Your Ref: OWPC24775
Our Ref: P/100/19/HH 10-10-2019
Please ask for:
Amber Willard

Single storey side extension and conversion of roofspace to habitable use to include a side dormer and conversion of roof from hip to gable end, and alterations to front bay windows

9 Kings Drive Pagham

dwg.title Proposed Elevations

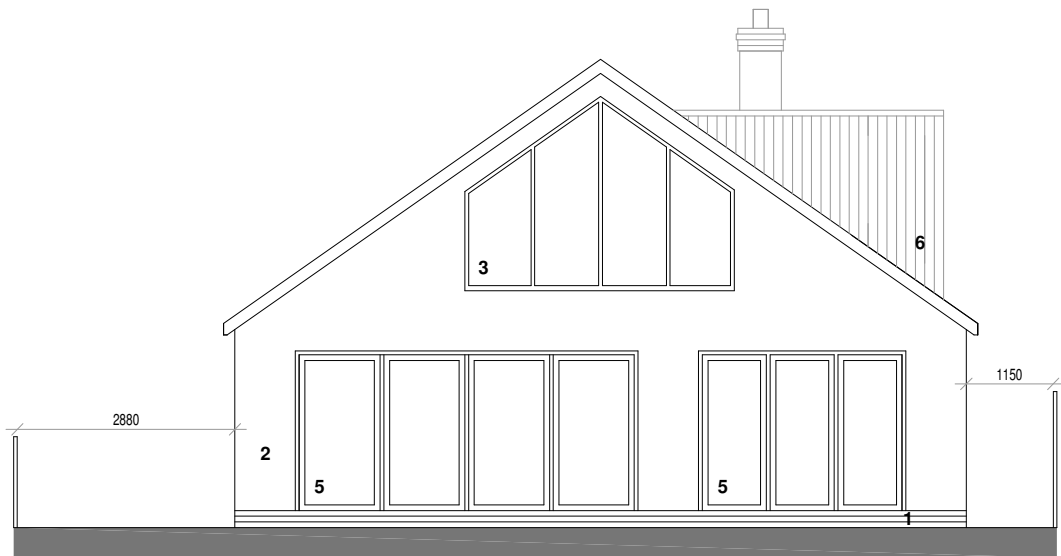
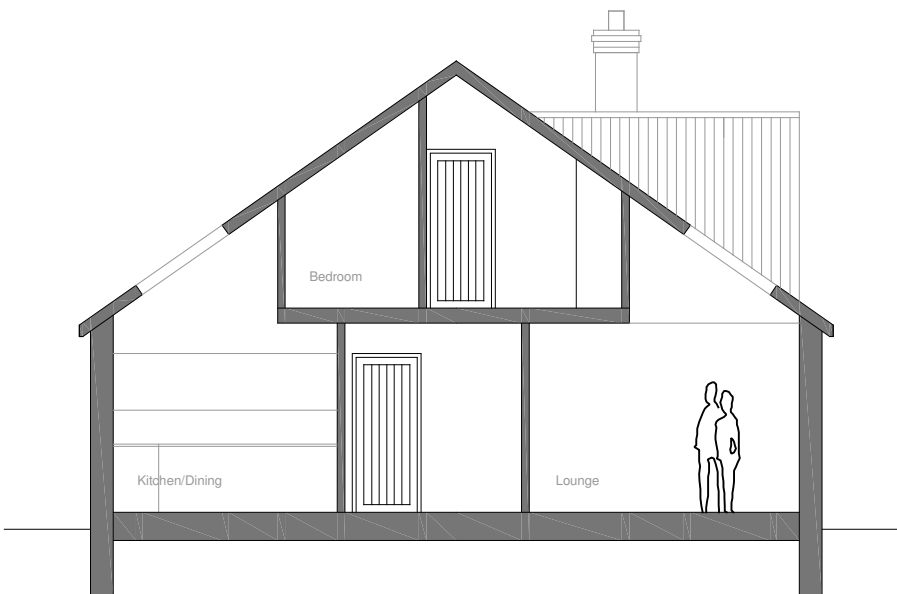
Our primary objection is with regard to the large dormer, positioned on the south elevation of the property. this will overlook our residence. We consider the size of the dormer to be excessively large, overbearing and intrusive to our privacy, as it will overlook the side of our residence, which has a narrow alleyway that we regularly use to access our rear garden. The additional height of this dormer will restrict the natural light to this elevation of the north side of our property and make the rooms on this side even darker than they already are. As the gap between both properties is under 4 metres, we consider that it would make the space claustrophobic and incongruous to its surroundings and the wider environment.

We also object to the extent of glazing proposed at first floor level at the rear of the property, which would directly overlook our rear garden. Trees would have to be removed to accommodate this development and this will result in the sudden loss and deprivation of our privacy.

We are concerned the size of this development would undermine and impact on our diminishing pipistrelle bat community, and also, within the surrounding environment. We seek assurance that the overall roof height at no 9 kings drive will not increase beyond its current level.
